From: [REDACTED]
To: [NI Enquiries](#)
Subject: Hinckley National Rail Freight Interchange Order Consultation - Sport England Ref: PA/23/EM/HIN/64582
Date: 10 October 2023 16:26:00
Attachments: [REDACTED]

The applicant has recently been in correspondence with Sport England regarding the extent of land forming parcel 11 which adjoins a rugby playing pitch and car park. The applicant has confirmed that the extent of parcel 11 comprises of land within the existing highway boundary. The relevant extract from the Book of Reference has been provided (copy attached) which confirms that the land amounts to 68 square metres or thereabouts of public adopted highway in the ownership of National Highways Limited and Leicestershire County Council.

From: Sharron Wilkinson
Sent: Tuesday, June 20, 2023 5:14 PM
To: NIEnquiries@planninginspectorate.gov.uk
Subject: Hinckley National Rail Freight Interchange Order Consultation - Sport England Ref: PA/23/EM/HIN/64582

The playing fields at Leicester Road Sports Club involved in this proposal includes a cricket pitch used by Hinckley Town Cricket Club and a rugby pitch used by Hinckley Rugby Club. Drw No: 1842-8018_003341 rev V12 (Interchange Land Pla

Hincley National Rail Freight Interchange Land Plan Sheet 1 of 8

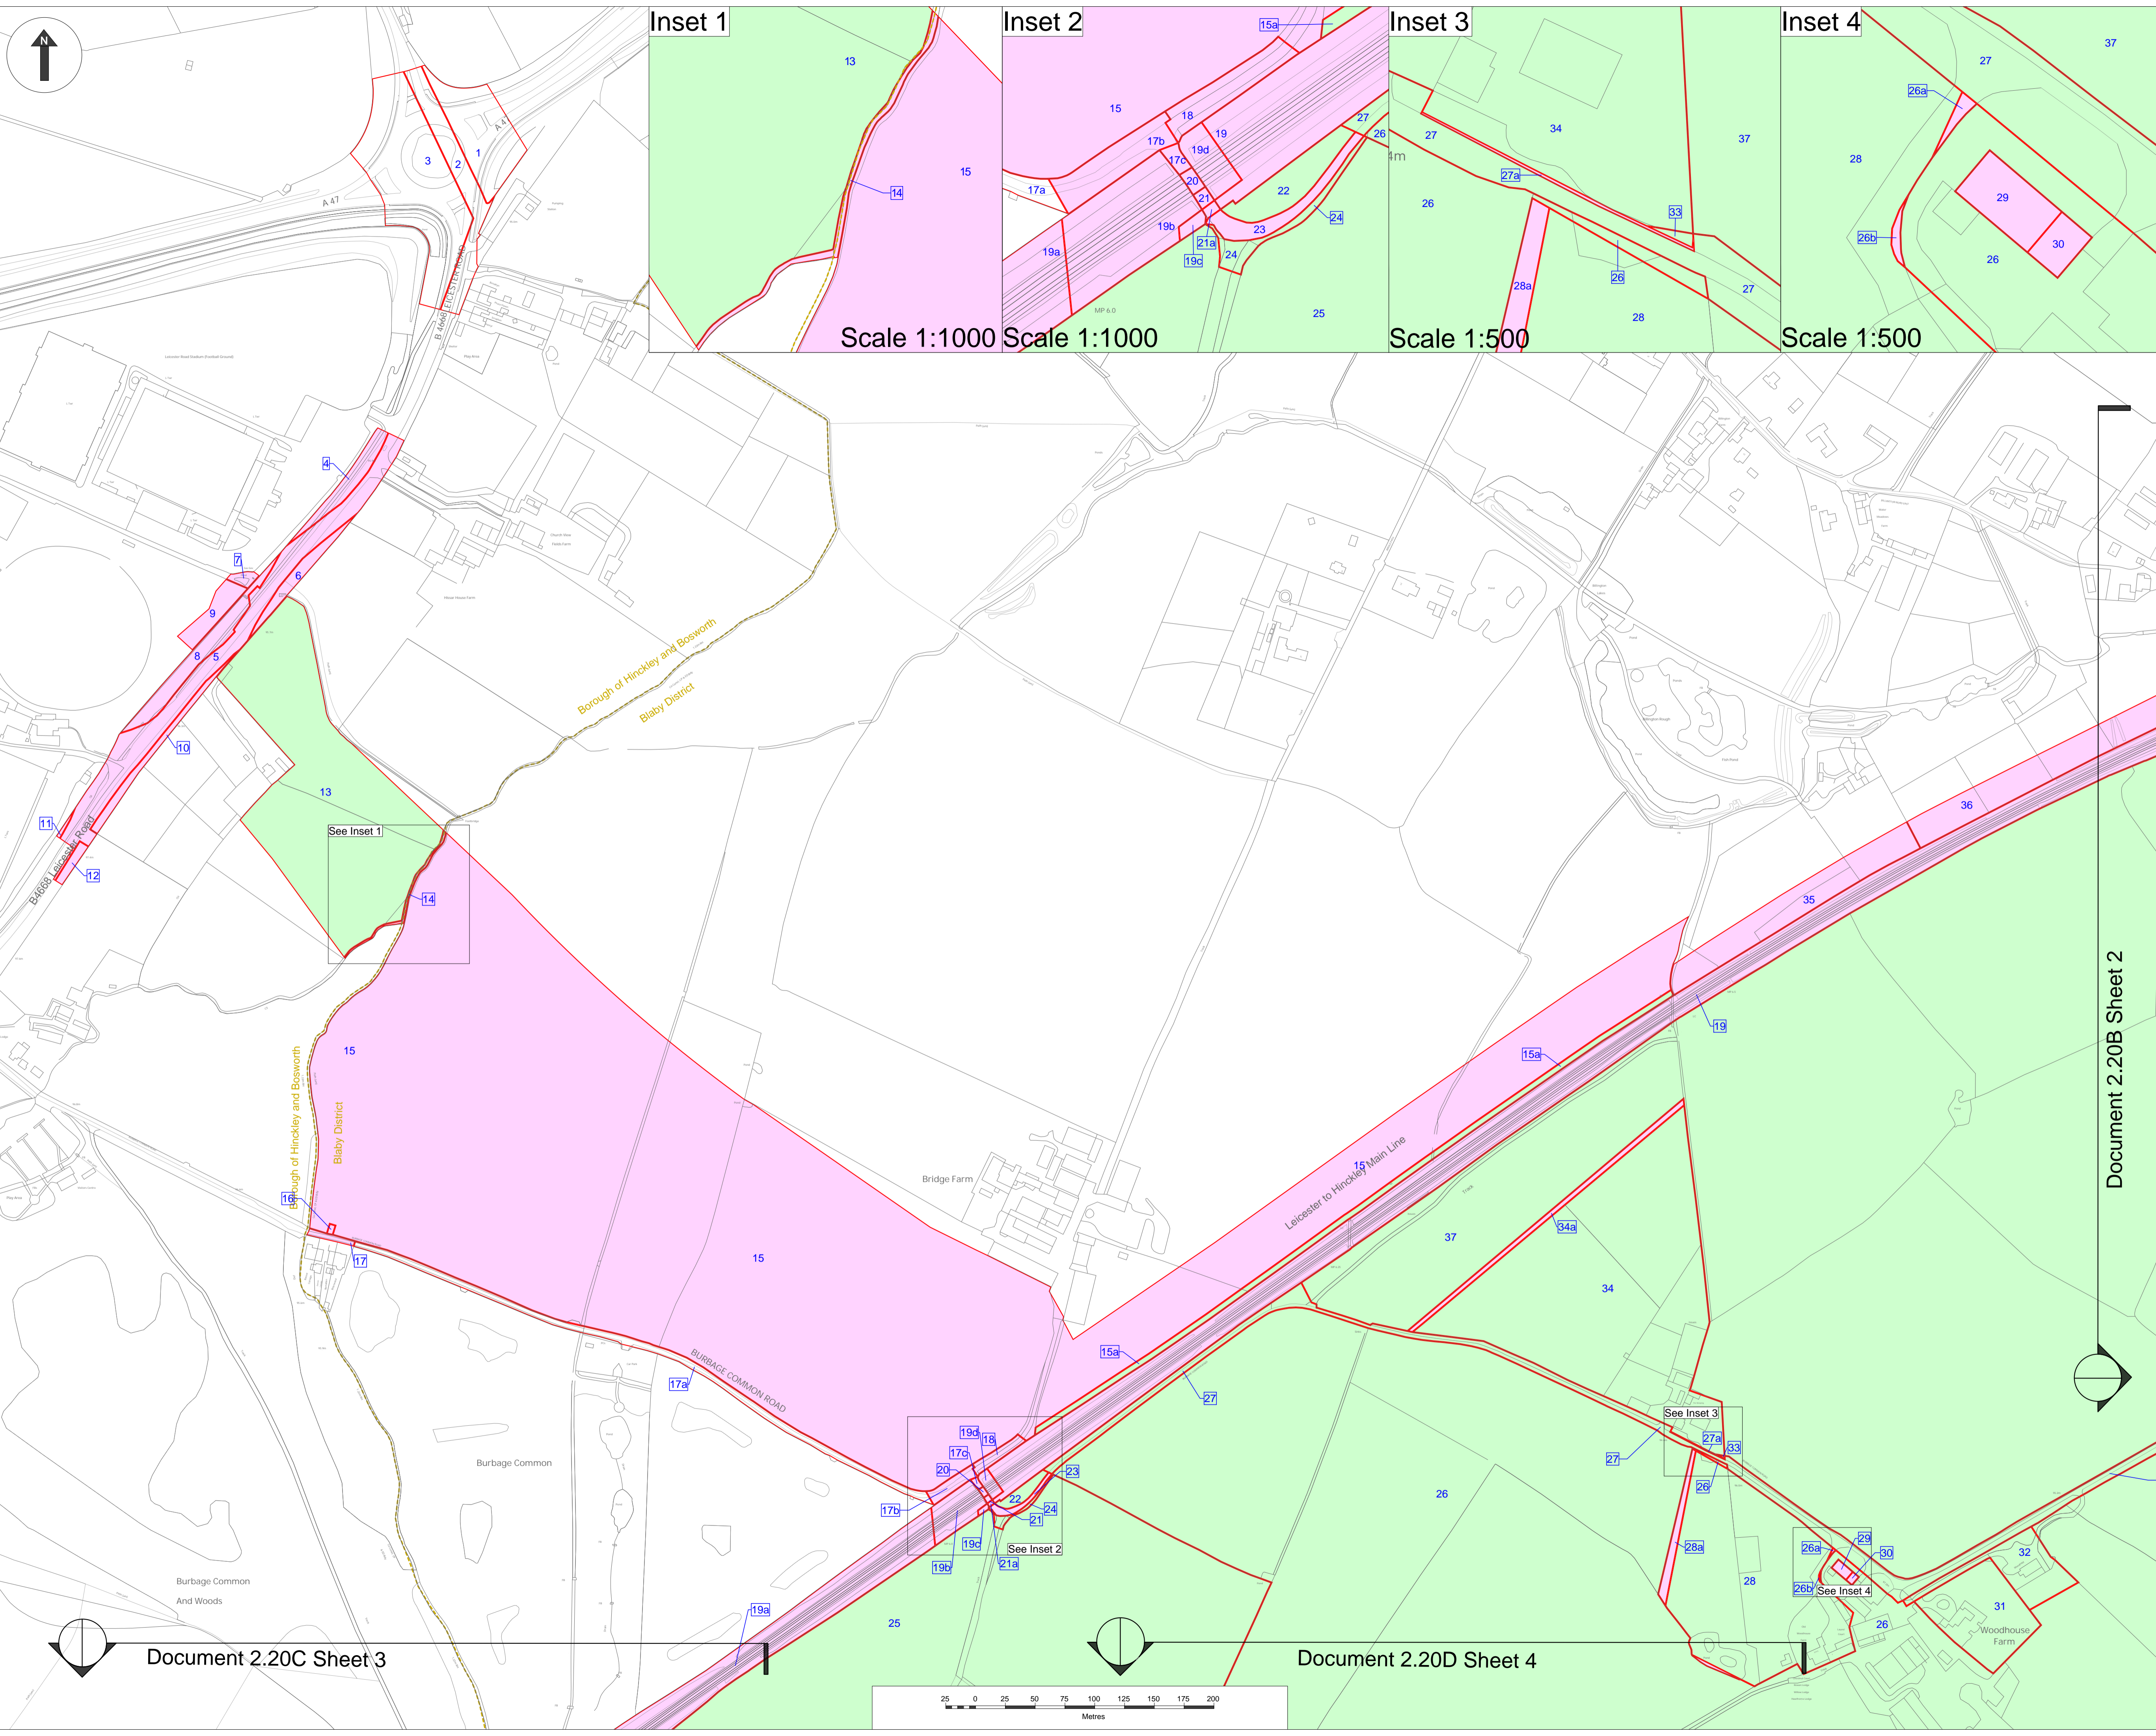
However, there is the potential for significant adverse effect on the rugby pitch used by Hinckley Town Cricket Club arising from this proposal for highway improvement works which would be next to the pitch. To enable the proposal to be assessed against paragraph 187 of the NPPF which seeks to protect sports club from development permitted after they were established, further information should be provided by way of a ball strike risk assessment to assess how the proposed highway improvement works would impact on the use of the rugby pitch. Based on the results of the assessment a ball stop fence may be required. Full details would be required on the siting and height of the fence and the materials to be used for its construction. Details would also be required on how the fence would remain in perpetuity and be maintained in the future.

Further details would also be required as to how the existing level of car parking for the site would be retained as the proposal would include some land which is currently used for car parking.

Based on the above information it is agreed that highway improvement works within parcel 11 would not have an adverse effect on the rugby pitch or car park used by Hinckley Rugby Club. Therefore, a ball strike risk assessment is no longer required. Further details on how the existing level of car parking for the site would be retained are also no longer required.
